M/124/17/PL

PLAN-021075

Proposal: Retention of salon, erection of first floor extension & two storey rear extension to create 1 No. duplex apartment (resubmission following M/86/17/PL).
Site: 74 Elmer Road, Middleton on Sea, PO22 6EX.
M/124/17/PL

Drawn By L.O. Dwg. No. 010817 / SL-30 A

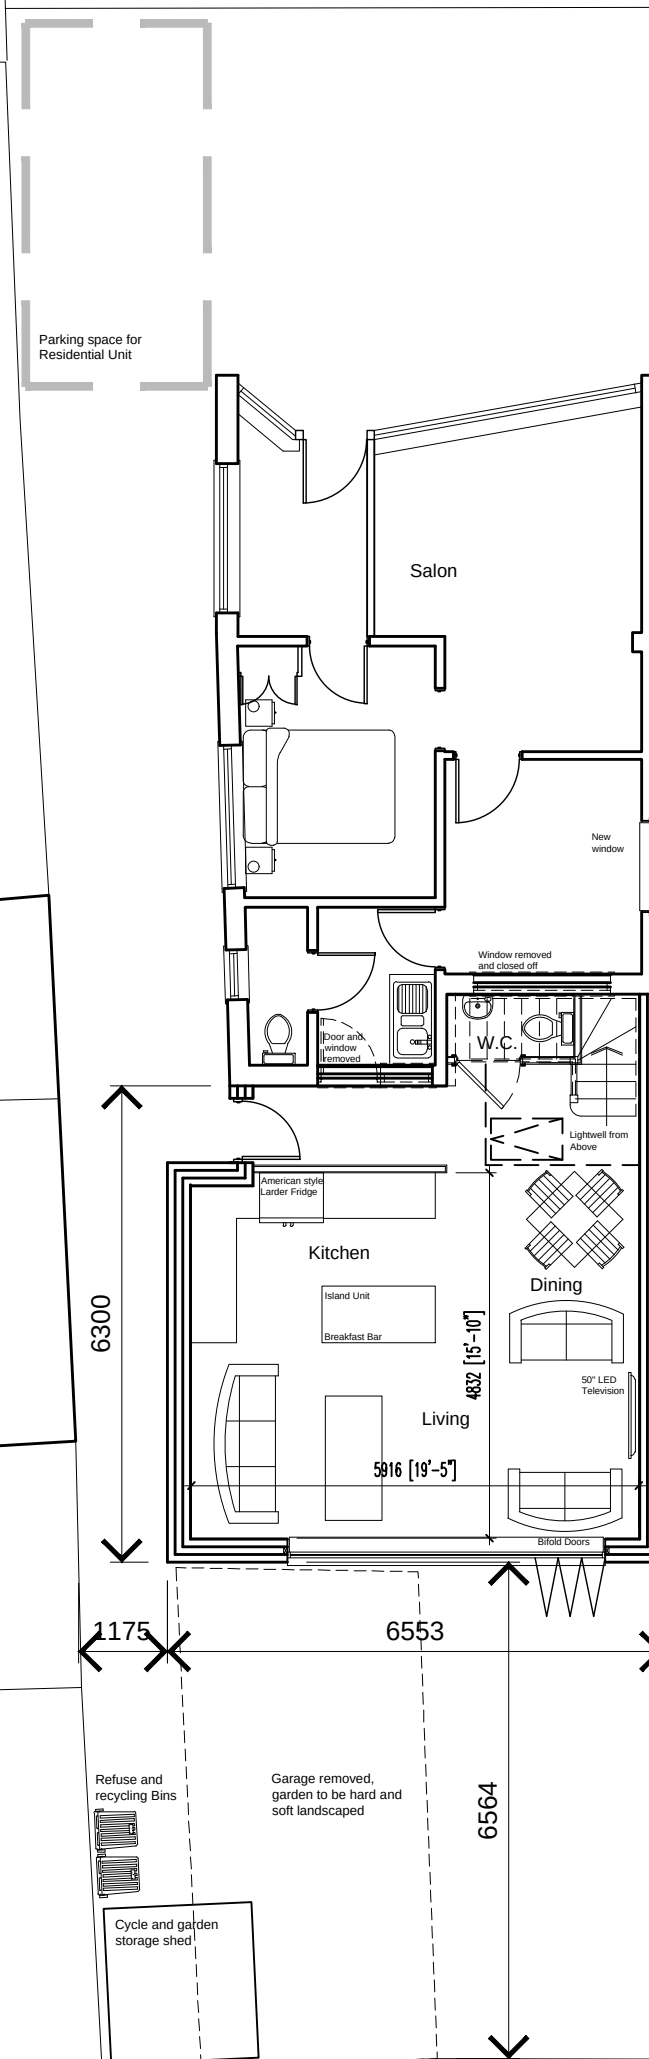
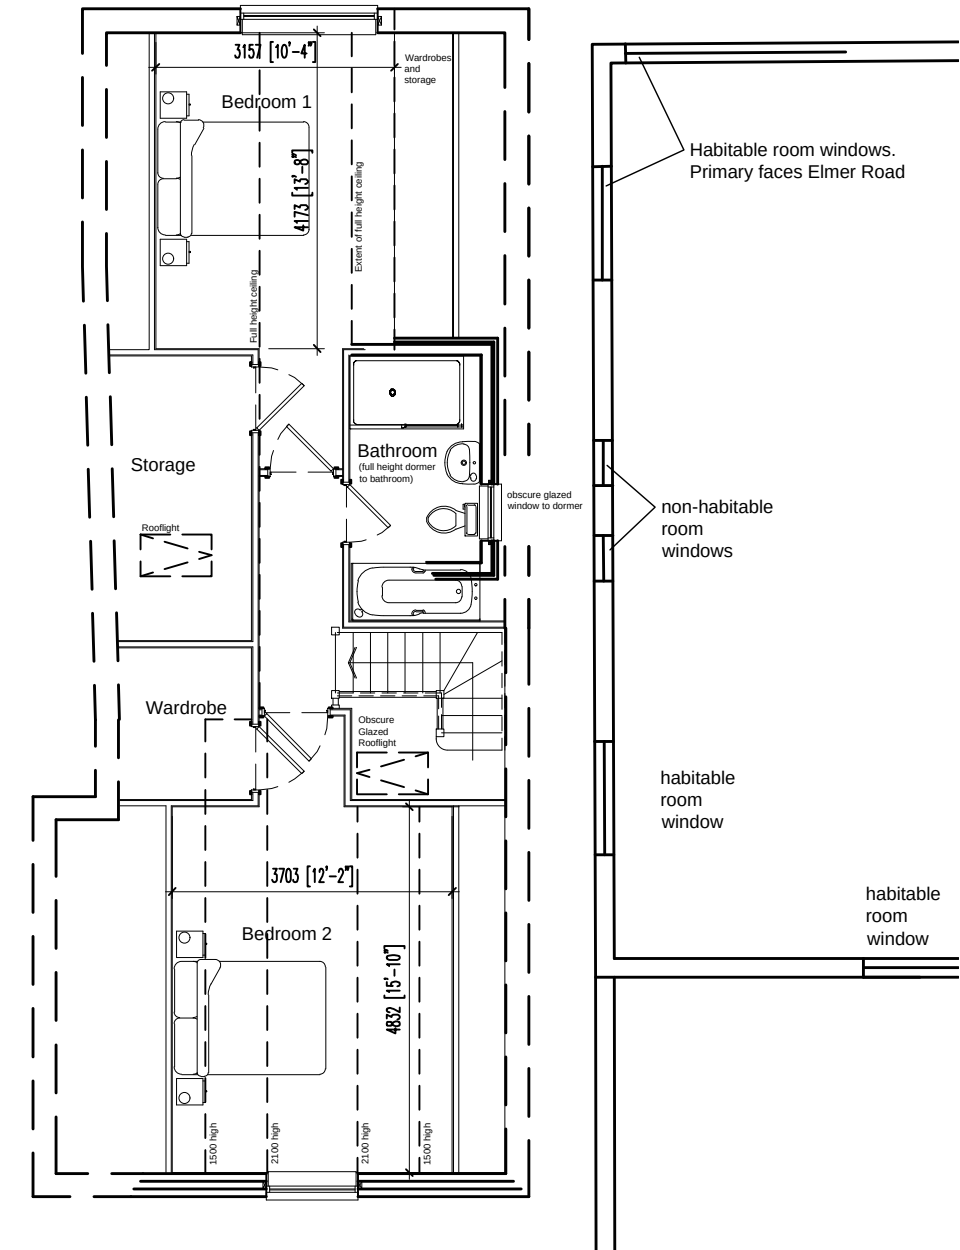
It appears that the developer is intending to build over to a public foul sewer which is crossing the site. Building over a "public sewer" is not normally permitted by Southern Water.

However, under certain circumstances building over a sewer may be allowed. The conditions associated with the buildover to a sewer are contained in Southern Water guidance notes which are available at: www.southernwater.co.uk. A formal application to build close to the sewer will required to be submitted by the applicant.

Alternatively, if building over the public sewer will not be possible, the diversion of the public sewer will be required.

In order to protect drainage apparatus, Southern Water requests that if consent is granted, a condition is attached to the planning permission. For example "The developer must advise the local authority (in consultation with Southern Water) of the measures which will be undertaken to protect the public sewers, prior to the commencement of the development."
